Please ask for: Ms Iqraa Malik
Email: iqraa.malik@terraquest.co.uk
Telephone: 0121 234 1390
Our Ref: WA/111/21/HH
Your Ref:
Date: 7th December 2021

Application for Planning Permission for Works or Extension to a Dwelling

Development: Erection of two storey front and rear extension with first floor rear balcony following demolition of existing rear conservatory.
Location: Highdown West Walberton Lane Walberton BN18 0QS

DRAWING TITLE
LOCATION AND BLOCK PLAN

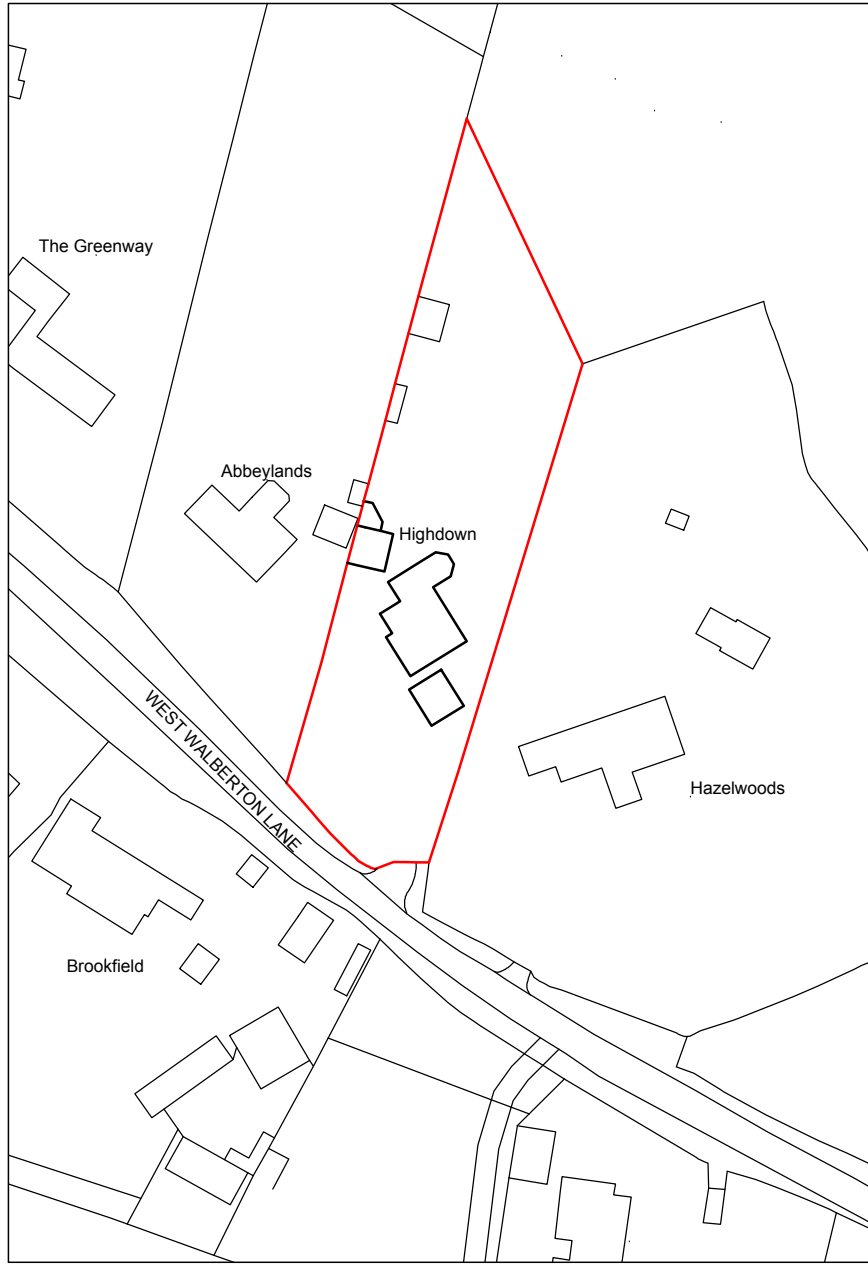
You are required to have dimensions from the proposed extension(s) to all site boundaries. Please amend.
